Our reference: P-945635-X1X8
Contact: Hannah Vousden
Telephone: (02) 4732 7646

30 July 2025

**Council Response to EIS – SSD-80264236 – 200 Aldington Road
Industrial Estate Stage 3 (Lot K) – 106-228 Aldington Road, Kemps Creek
(Lot 200 DP 1285691)**

Figure 3-2: Lot K Site Plan - Key Building Features

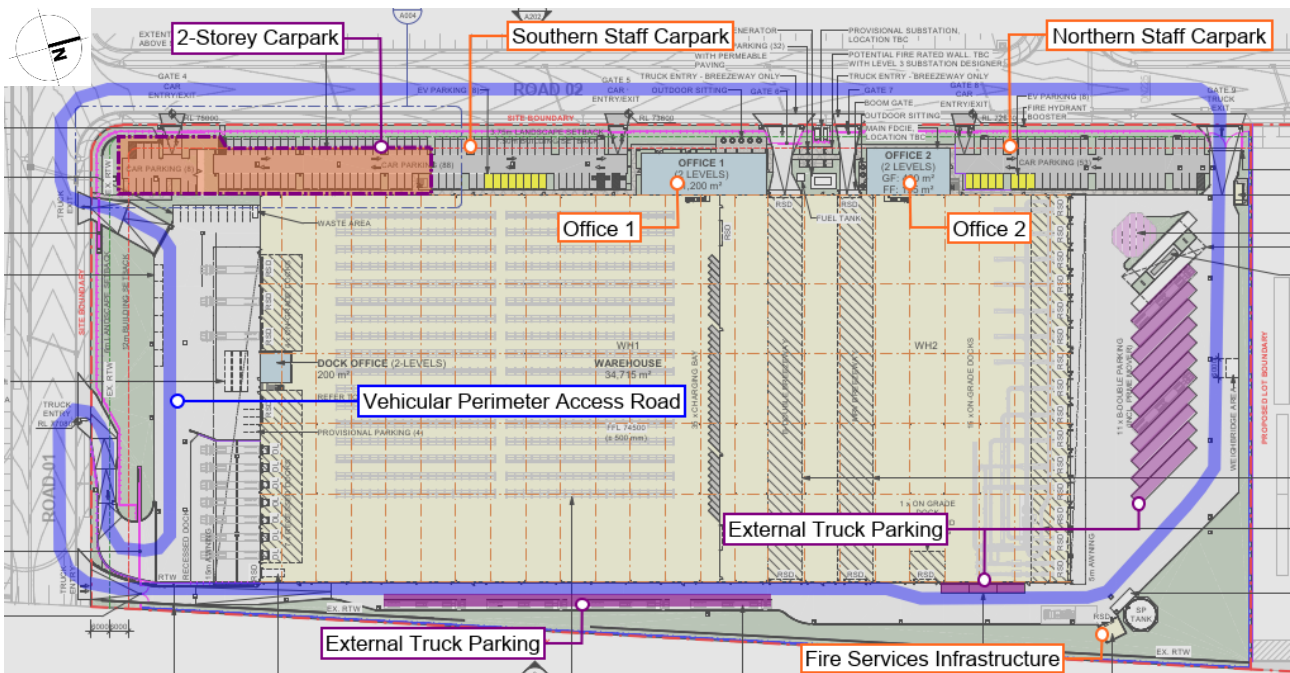
- c) As per the architectural plans submitted, the parked trucks will impact access to B-Double parking bays and would need to be managed. This could be addressed by a plan of management for the loading docks.

Figure 7-4: Vehicular Perimeter Access Roadway around the Building – Areas of Non-Compliance Highlighted

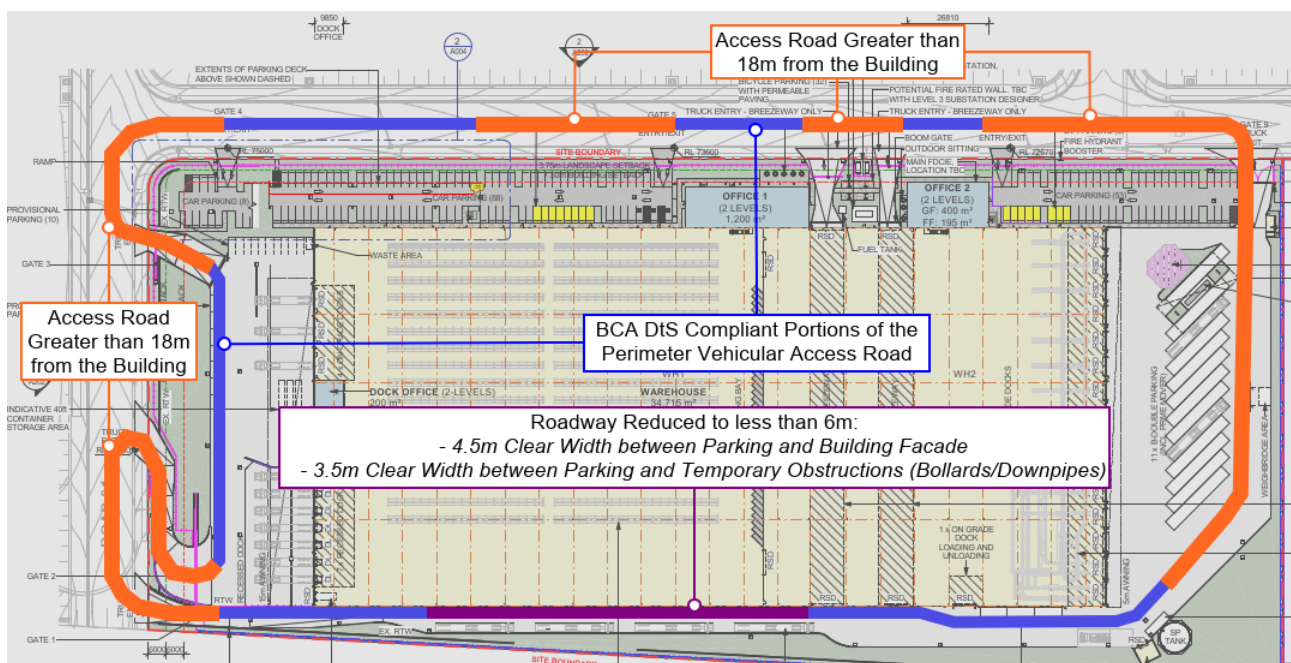
- f) The application should demonstrate that appropriate access and movement paths are maintained for the fire brigade, even when B-doubles are parked along the eastern hardstand area.
